**SUBMISSION re Environmental Impact Statement  
for State Significant Development Application for M2 Site  
in North Ryde Station Urban Activation Precinct, North Ryde (SSD 5093)  
by John McCain and Diane Michel**

### **III. DIRECTOR GENERAL’S REQUIREMENTS, SSD 5093**

Site Plan

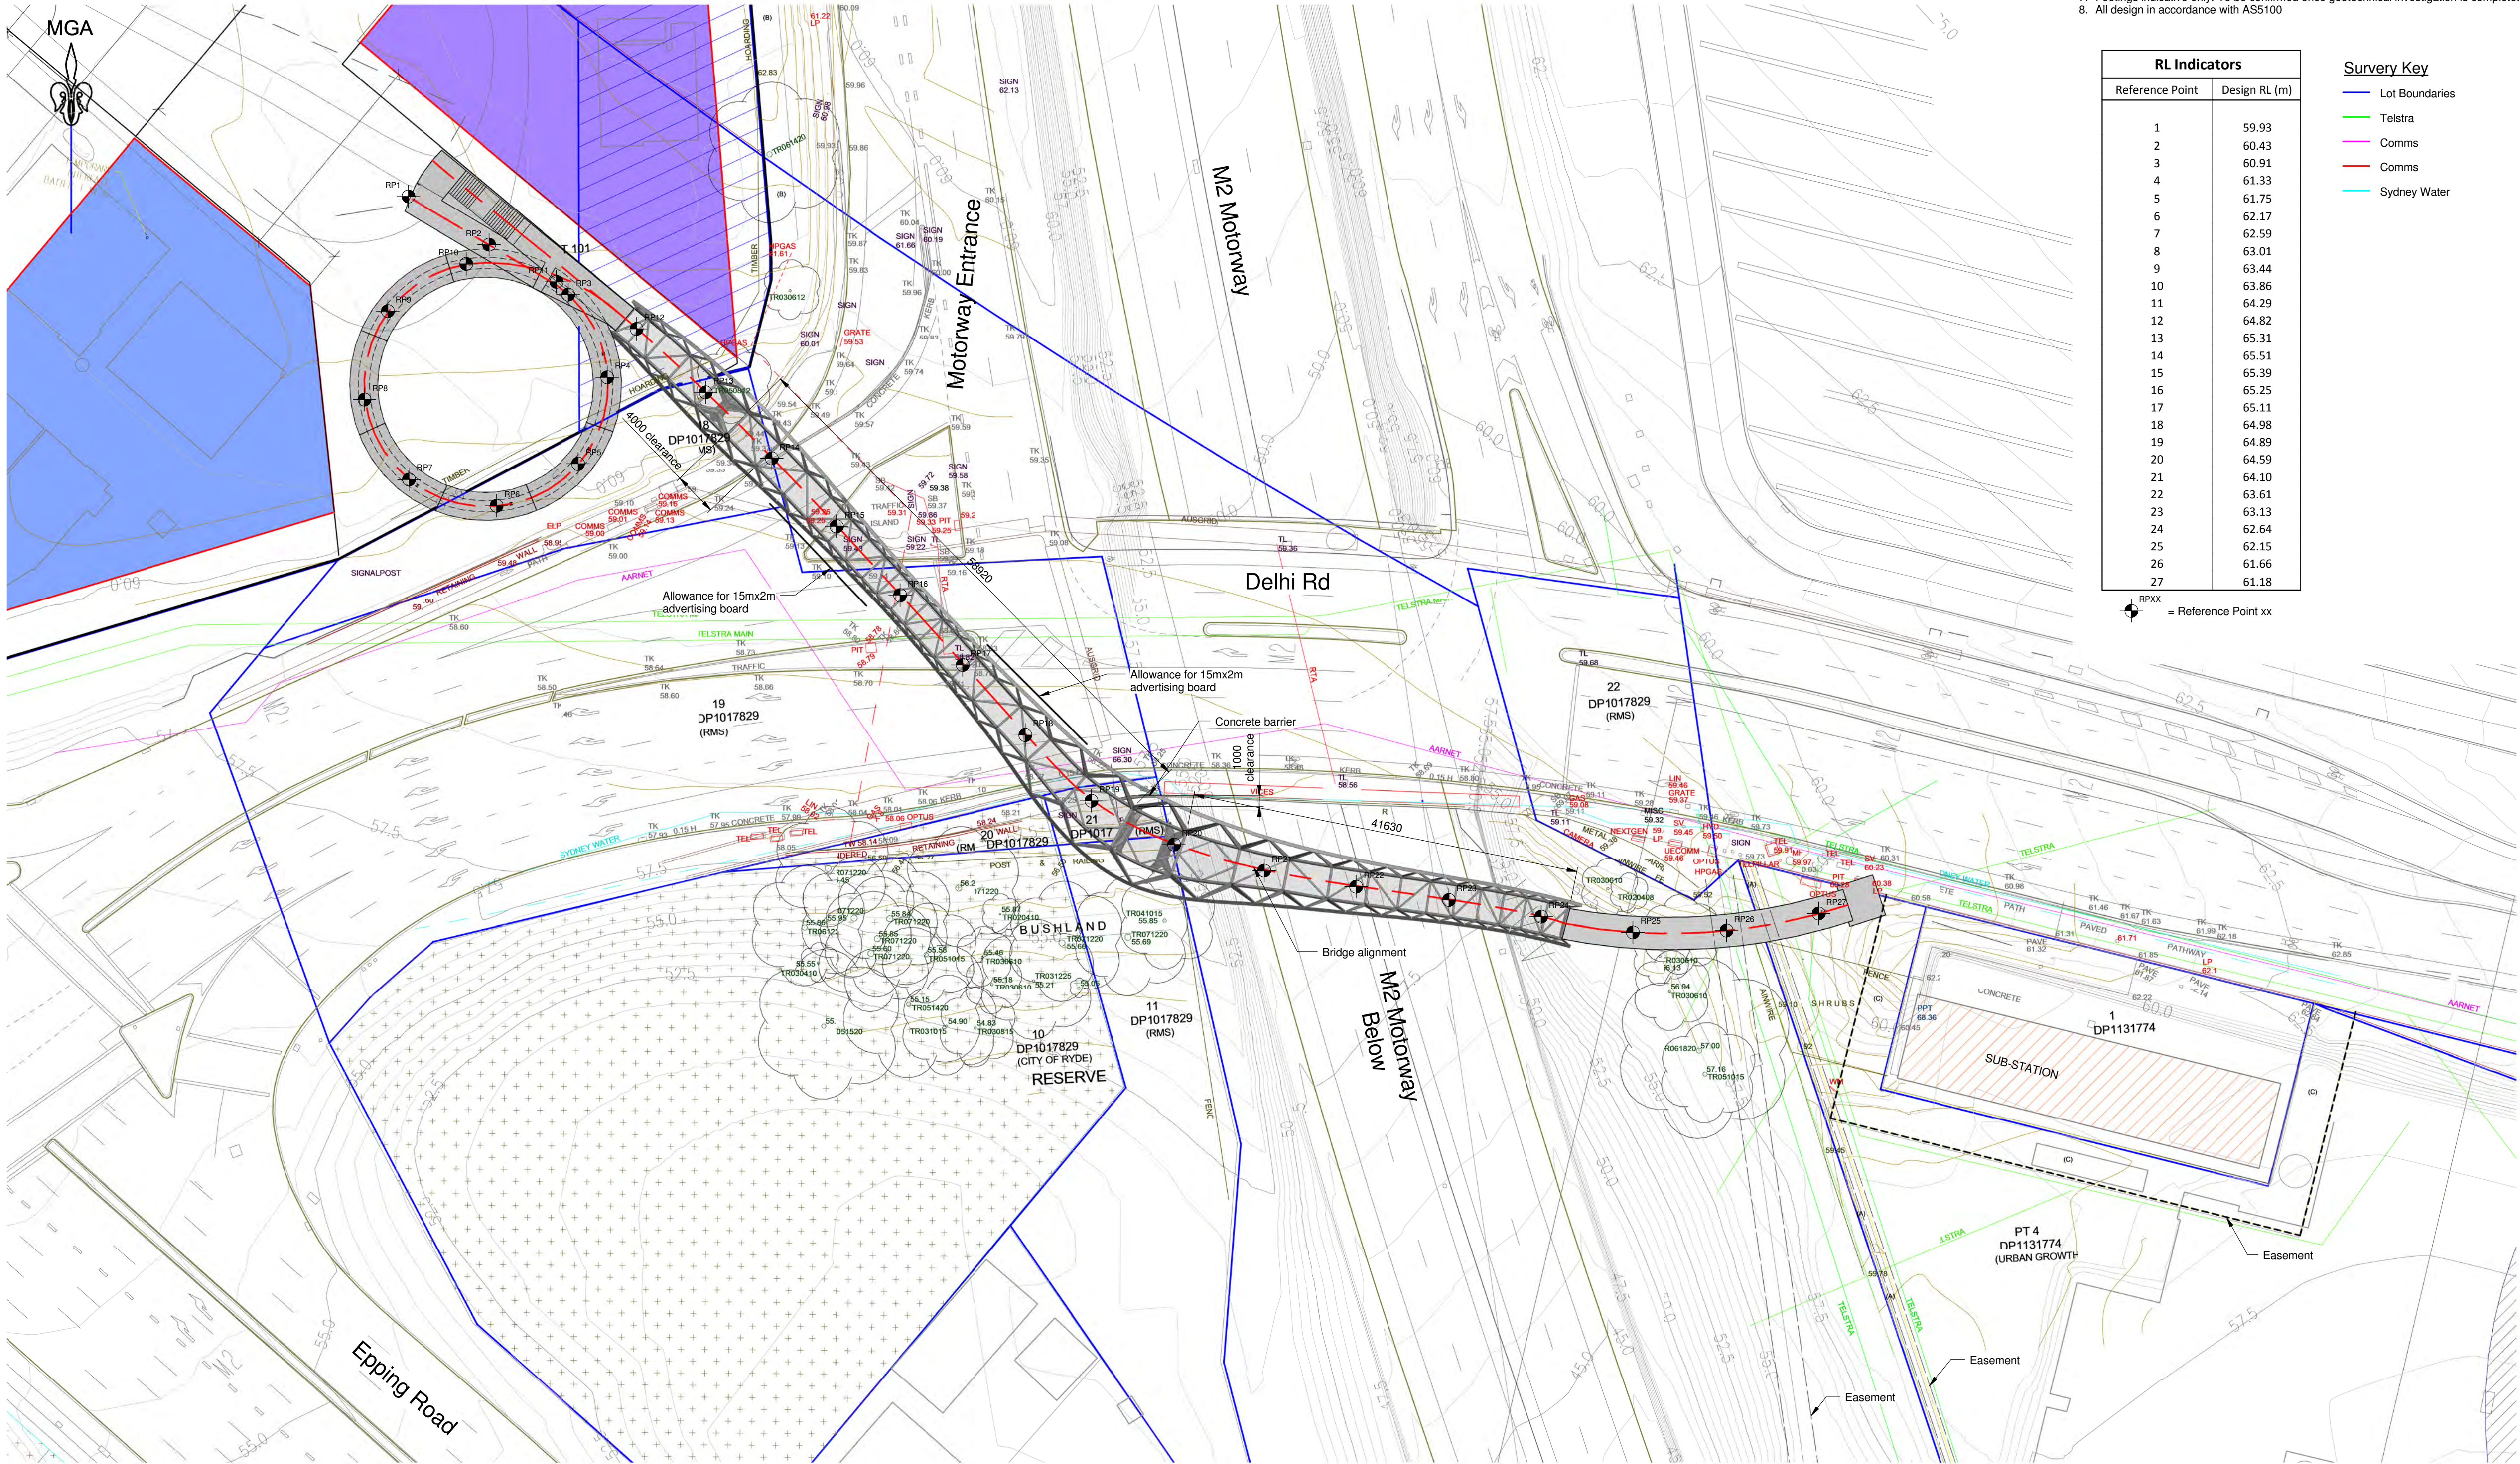
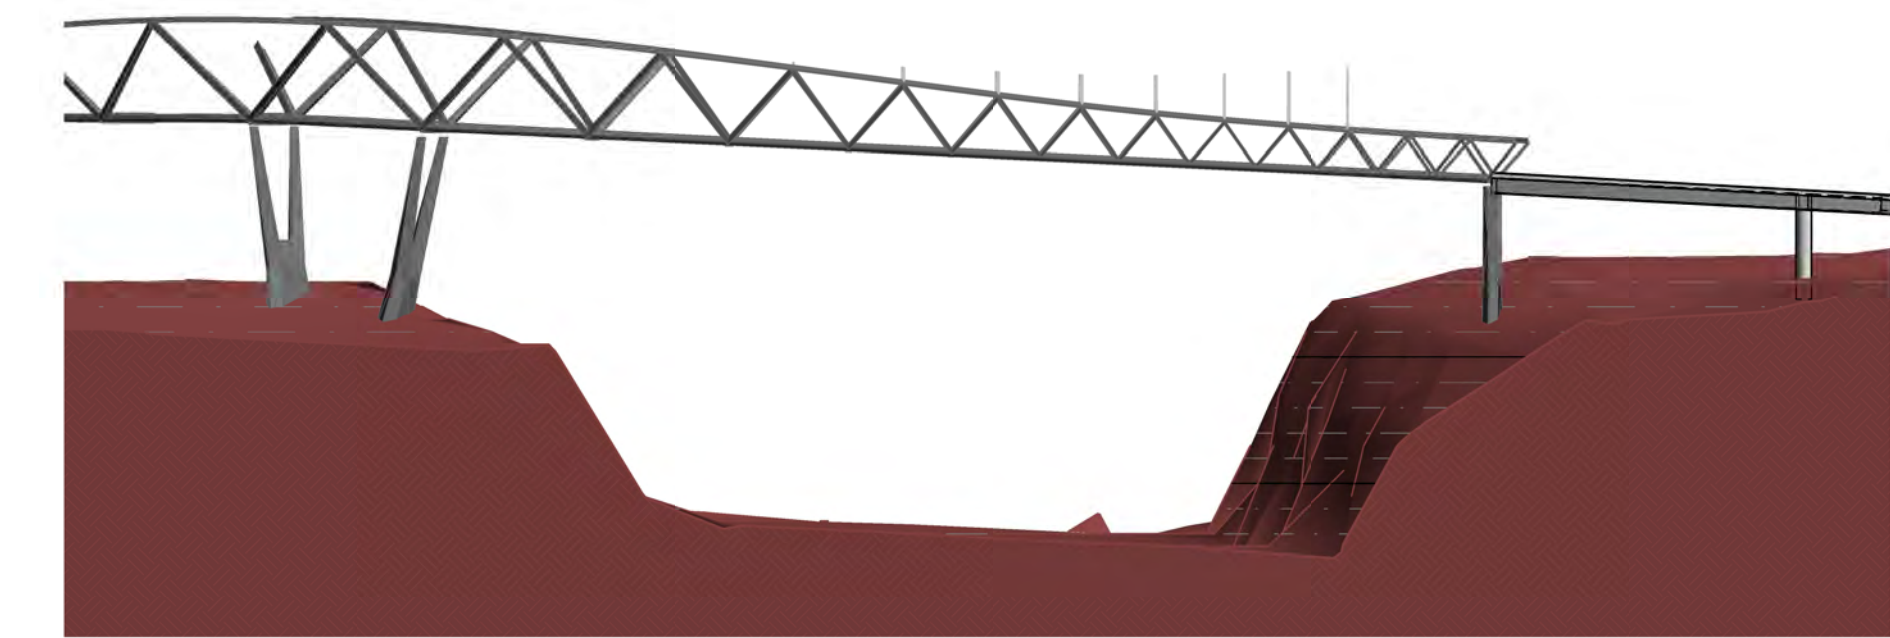
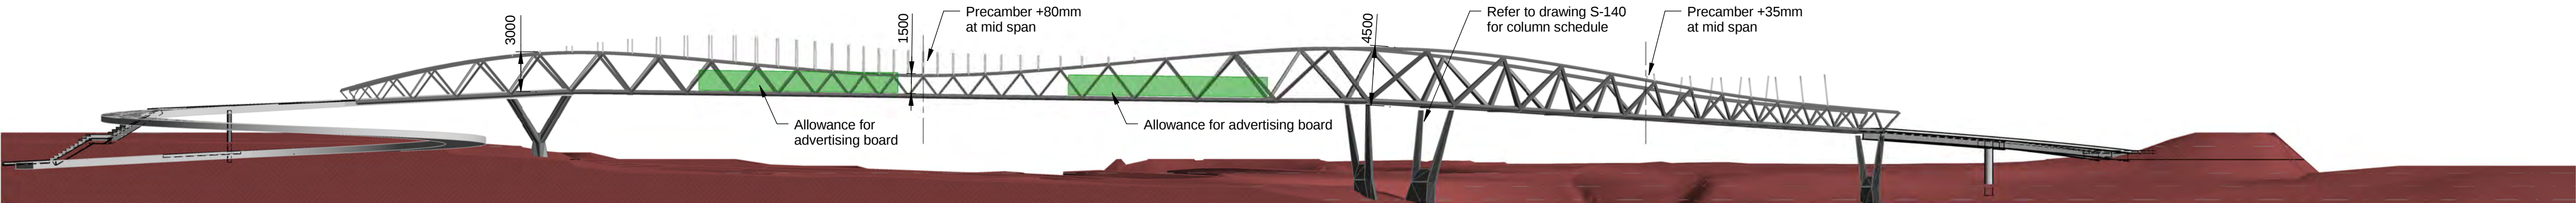
More importantly, the DGRs fail to mention two places on the east side of Delhi Rd which will be the site of supports for the substantial pedestrian-cycle bridge. Omission of these two places from the DGRs’ location statement would appear to have deprived them of serious attention in the Ecological Impact Assessment, Vegetation Management Plan and Construction Environmental Management Plan.

A double support for the overbridge is proposed for a very tight corner of RMS land at the NW extremity of Bundara Reserve. Presumably, this is why a *“biodiversity assessment of any potential impacts on Bundara Reserve”* appears first on the Director General’s listed requirements concerning Biodiversity (although not recognised in the Location of the study site).

A sunshade is recommended for a position on the bridge, as near as possible to Bundara Reserve. This device would increase shading of a Turpentine Ironbark ecological community already due for impact from shading via buildings to be raised on the M2 Site. No relief from this environmental impact has been prescribed.

No visual (or safety) impact is predicted for a “15m x 2m advertising board” slung on the overbridge.<sup>4</sup> (There is no denying that the purpose of the advertising is to create a 24-hour distraction for Delhi Rd motorists. There is no admission that such distractions are both ugly and hazardous. Existing and proposed on-road advertising at Delhi Rd is positioned near complex merge lanes, access ramps, etc, where accidents are already common. At night, the illuminated advertising on the M2’s Delhi Rd bridge already is offensively visible from back windows on Epping Rd and within Bundara Reserve.)

Figure 4.10 Abstract 3D study of the pier configuration. The "V" shape form echoes the truss language and the diamond shape of the piers visually relates to the top truss chord and diagonals.

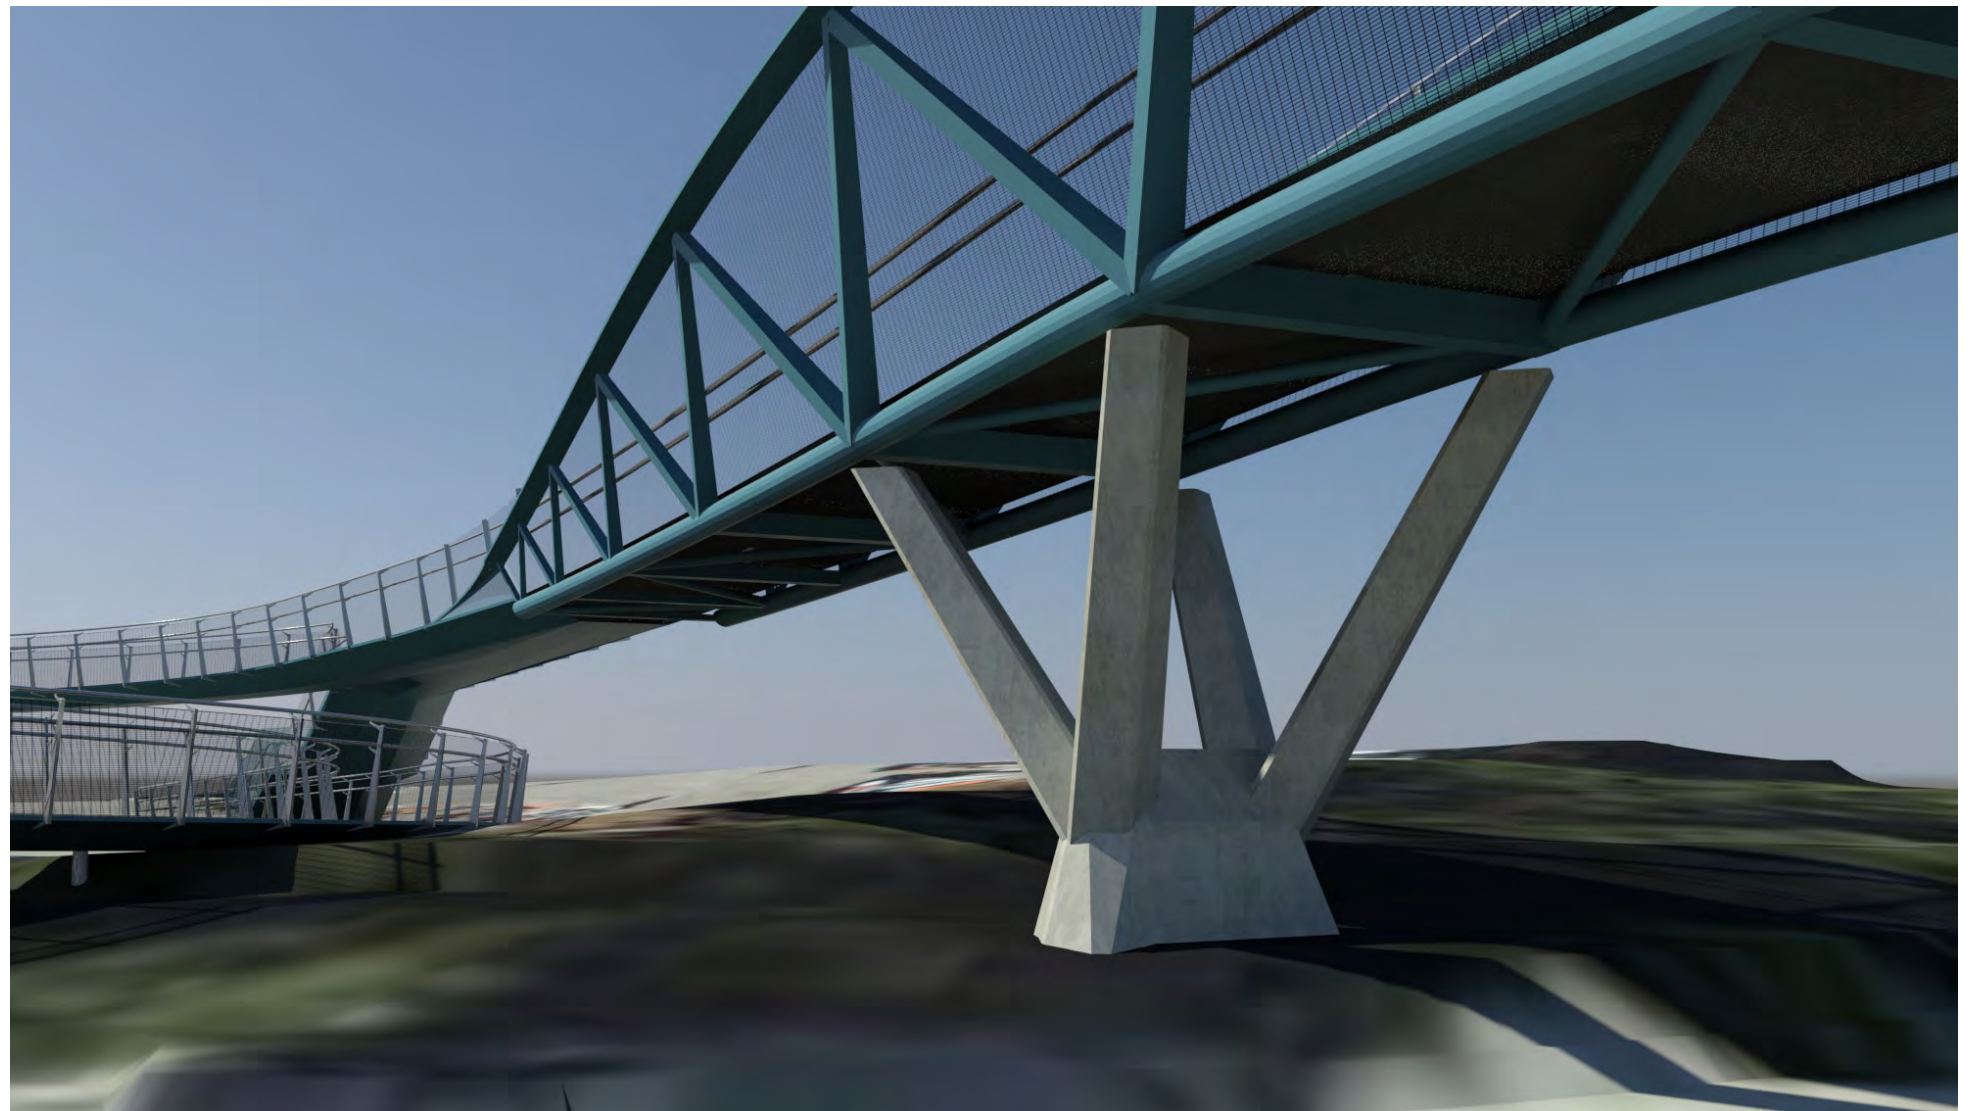
The bridge is more than outlined. A much-improved design is examined in considerable detail. Unfortunately, the bridge supports at two locations on the east side of Delhi Rd are not specified in the DGRs as part of the project Location. Although the bridge designers understood that the overhead crossing is a work associated with the project, consultants charged with environmental assessment took a differing view. Accordingly, there is no recognition of potential impacts on Bundara Reserve . . . and no suggestions for mitigation of inevitable impacts.
